PORTLAND MAINE

October 9, 2007

RE: 31 Melody Lane – 379 D005 – R-2 – front porch – permit #07-0675

SITE PLAN  
SCALE 1/16" = 1'-0"

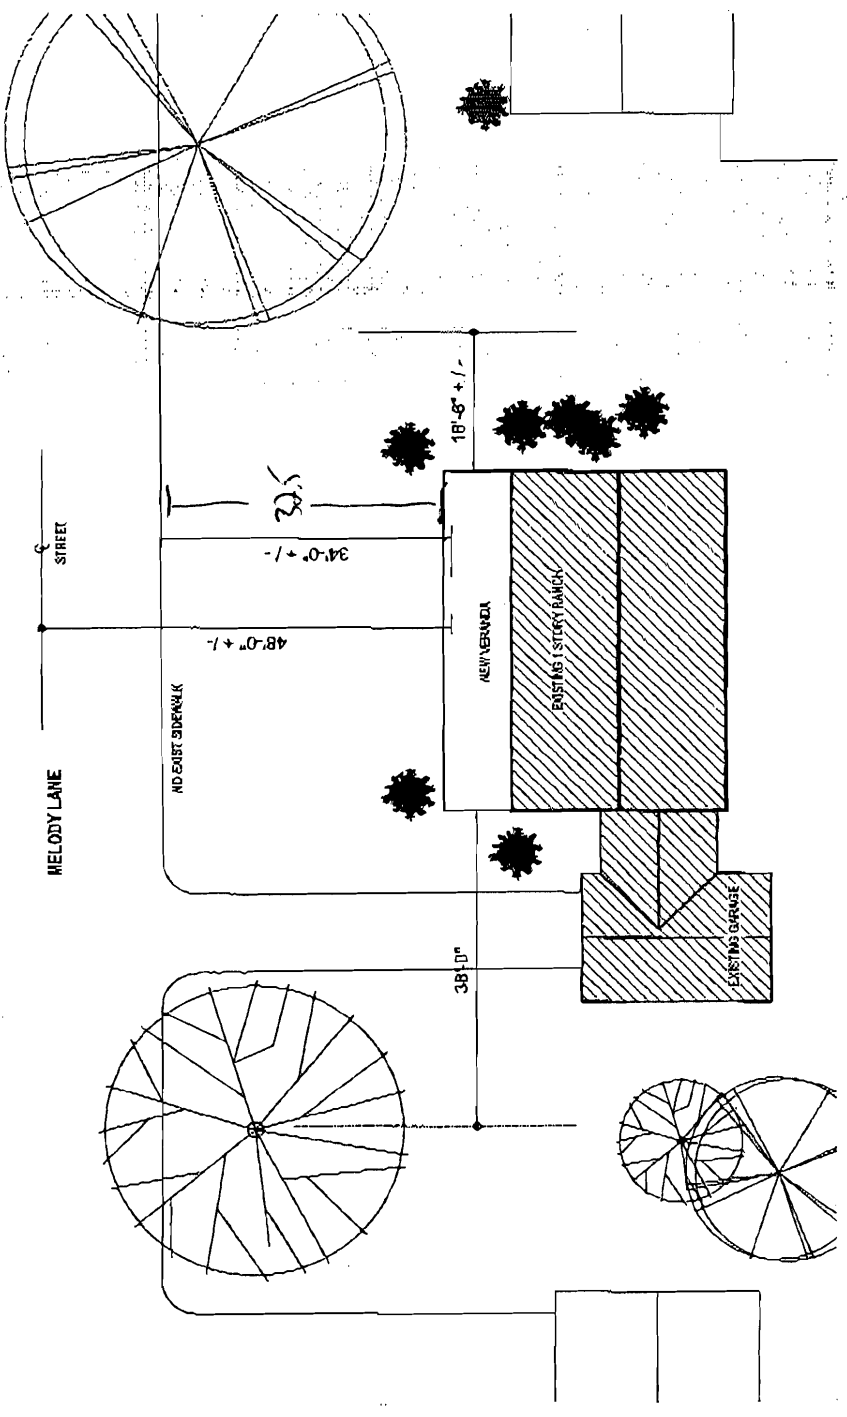
I am in receipt of your application to build a forty-two foot by seven-foot porch on the front of your house at 31 Melody Lane. Your property is located in the R-2 residential zone. The land use ordinance, section 14-80(d)(1) gives the required front yard setback in the R-2 zone as twenty-five feet. The plot plan submitted with your application shows the front yard setback for the proposed porch to be twenty-one and a half feet. Section 14-80(e) of the land use ordinance gives the maximum allowable lot coverage as twenty percent of the lot area. Your lot is 9,947 square feet. Twenty percent of that is 1,989.4 square feet. According to the assessor's office, the footprint of your existing structure is 1804 square feet. The square footage of the proposed porch is 294 square feet. With the addition, the total square footage of the footprint of the house would be 2,098 square feet, which is 108.6 square feet over the allowable maximum lot coverage. Since the proposed front porch does not meet the required front yard setback or the maximum allowable lot coverage, I must deny your application to build the porch.
